Your Ref :
Our Ref : EG/18/12/NMA

Section 96A of the Town & Country Planning Act 1990 (as amended)
Town and Country Planning (Development Management Procedure) (England) Order 2010 (as amended) - Article 9

Application for a non-material amendment following a grant of planning permission EG/14/09/L for various amendments to the ground & first floor
Shelly House & Elm Tree Stores, Nyton Road, Eastergate,

Client	MR G BRAMLEY / MR D TOBIN				
Job title	SHELLEY HOUSE / ELM TREE STORES NYTON ROAD, EASTERGATE WEST SUSSEX, PO20 3UP				
Drawing title	ELEVATIONS, AS PROPOSED				
Drawn	Date	Checked	Date	Scale at A1	
TR	05-09-11		05-09-11	1:100	
Job N°	Drawing N°		Rev.		
11-032	30-02			A	
Status

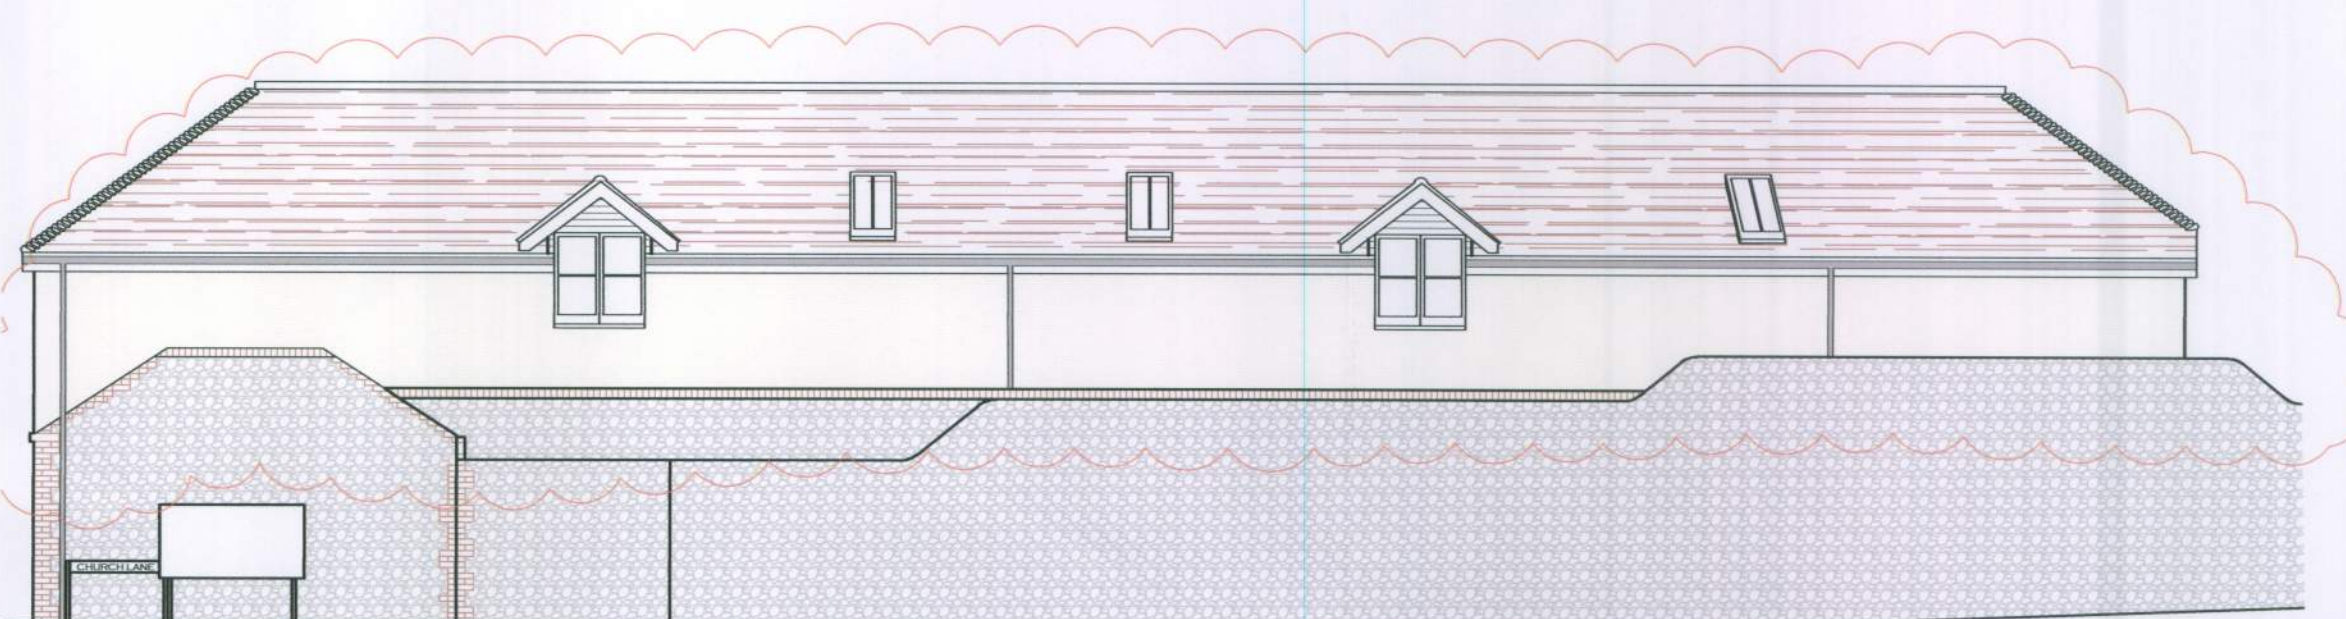
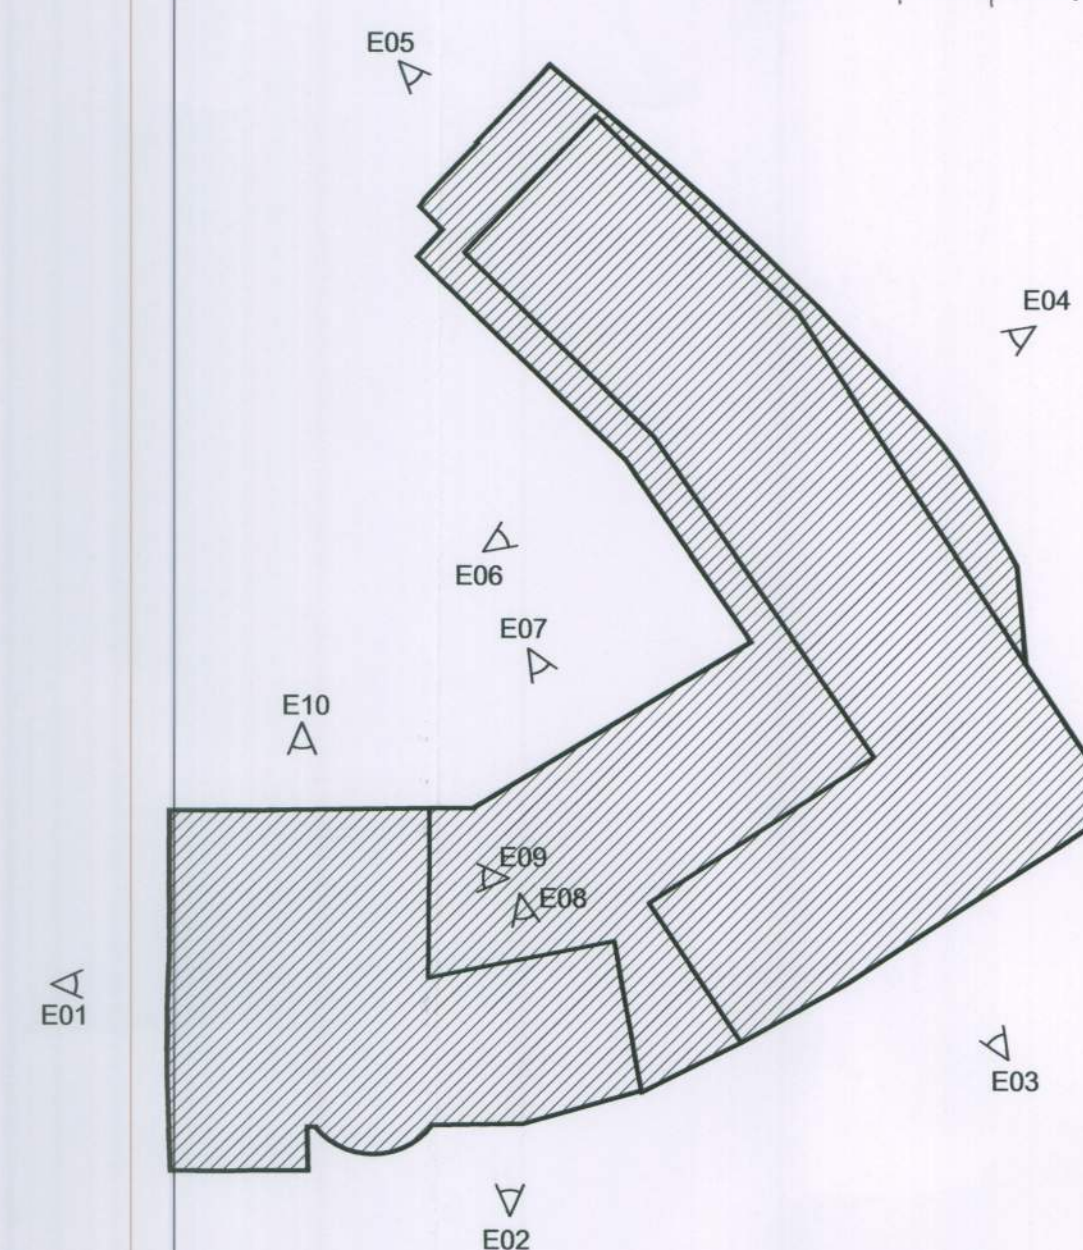
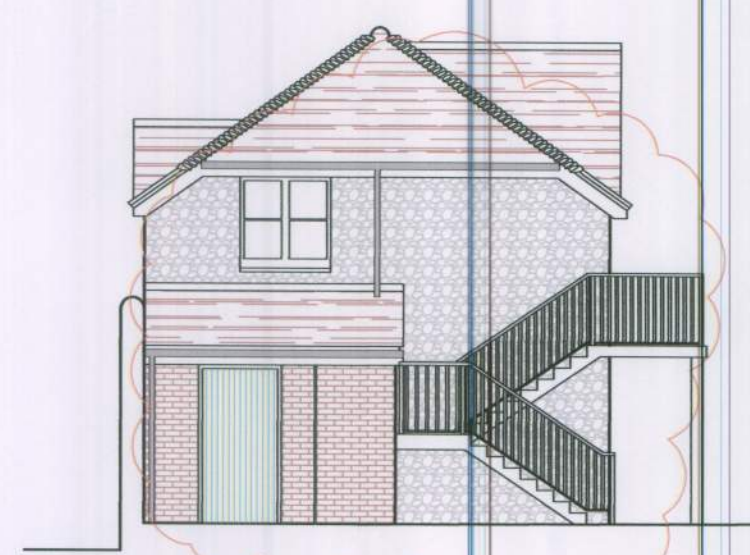
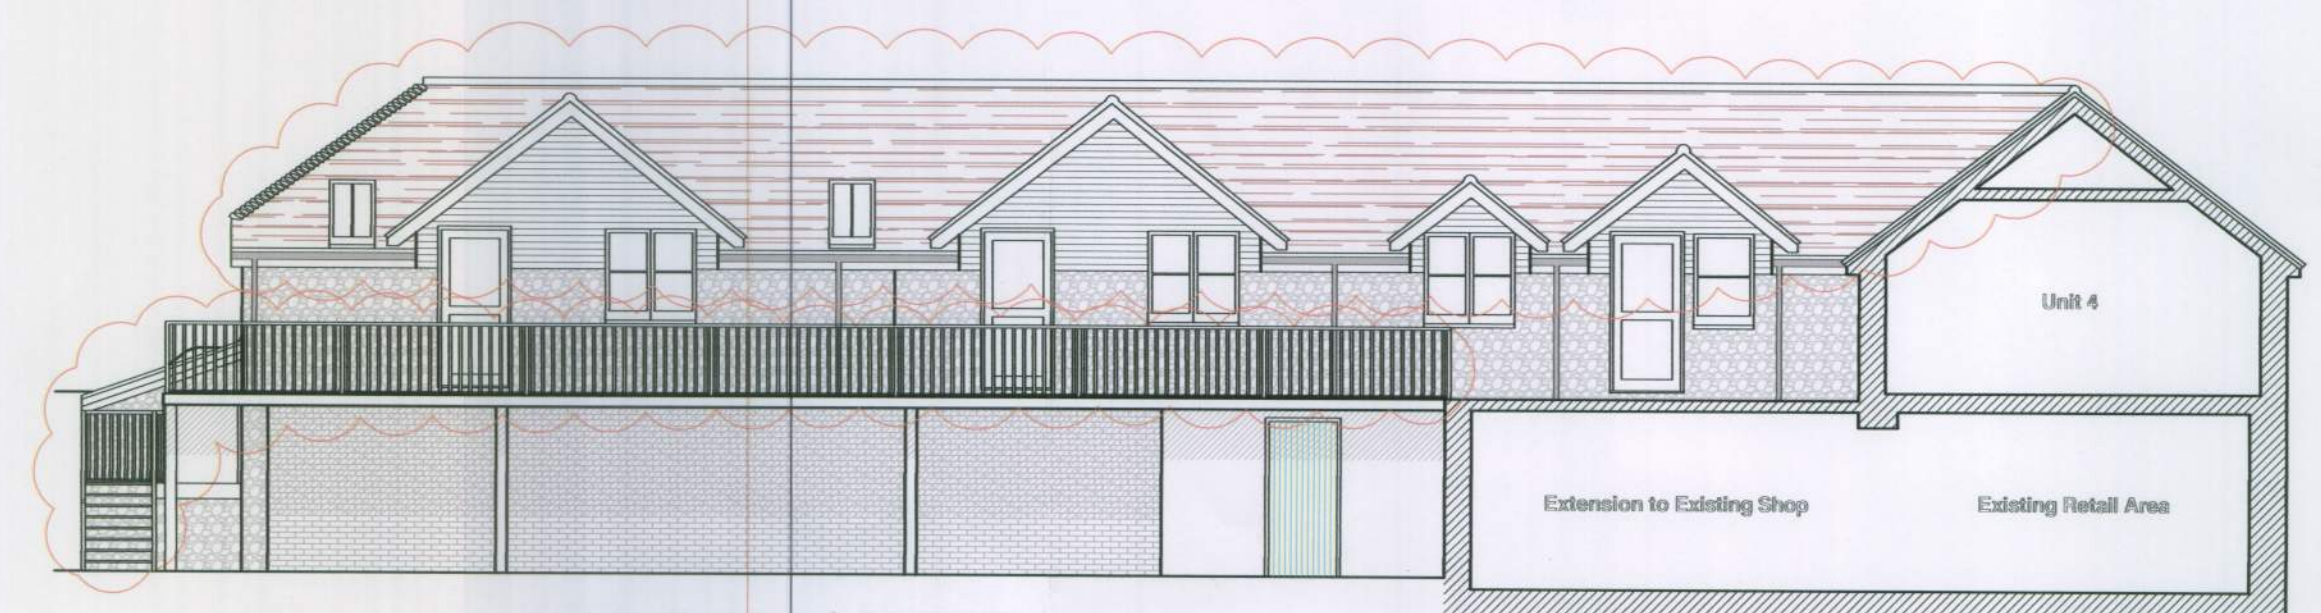
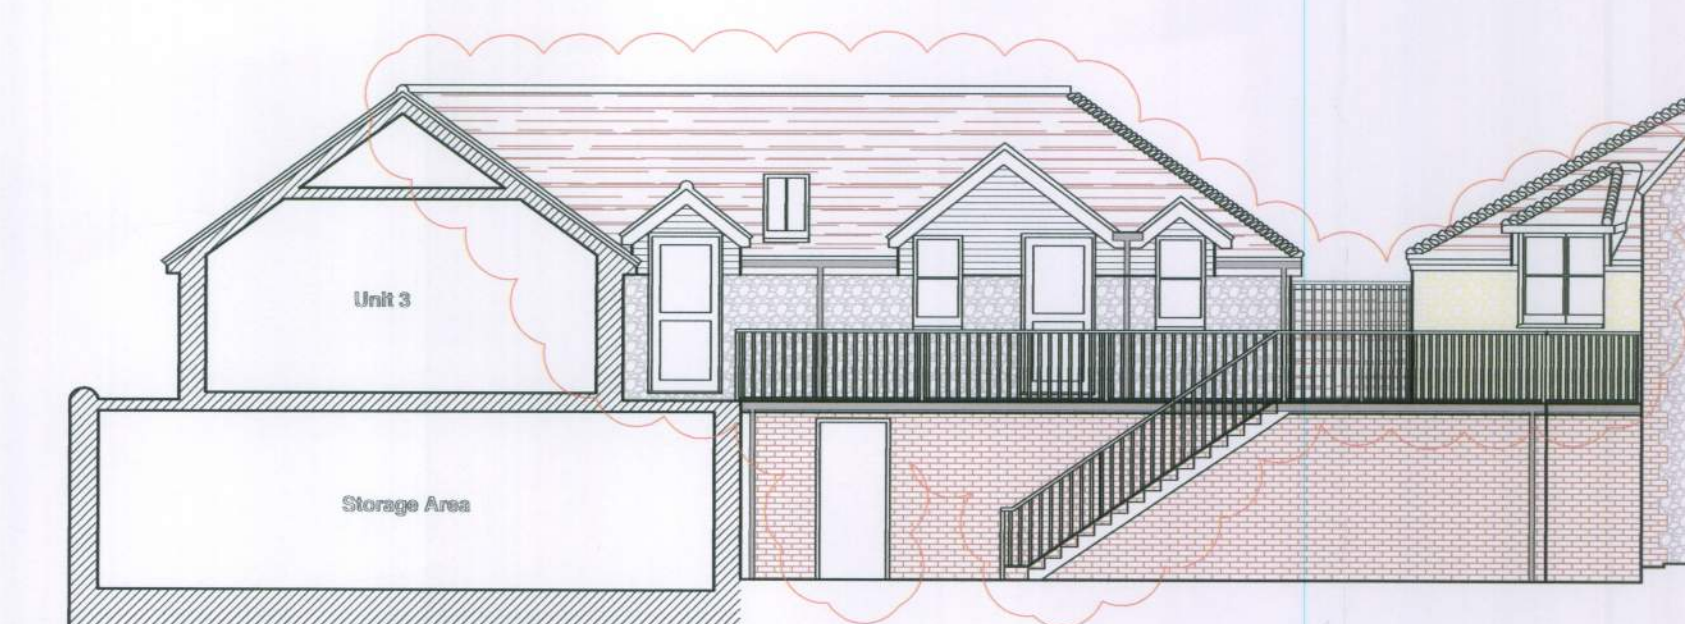
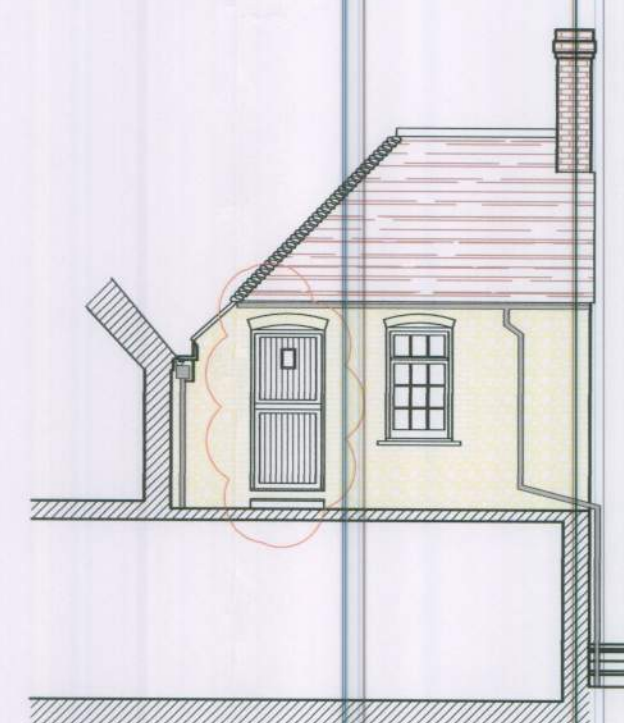
The Historic Buildings Advisor has commented that the main issue with these proposed amendments is the changing of the first floor elevations from flint to render. This is of particular concern on the front where flat render could contrast severely with the historic painted flint work below. On the Church Lane elevation there is further concern that the addition will simply appear as a new build and will not reflect any of the historic character or quality of the immediate location. This is important to other listed buildings such as Old Farm Cottage opposite, whose setting and appreciation could be affected by such a change. Given the height and scale of the extension and addition, there are also some reservations with the use of clay tiles, which might be seen to compete with the roofs of the main dwelling and shop. In its current form, the attached outbuilding is distinct in terms of both its height and roof treatment which is slate. This should be maintained to retain architectural clarity. Whilst two roof lights have been permitted, further windows should be avoided to maintain the listed building's character and appearance, particularly within a Conservation Area.
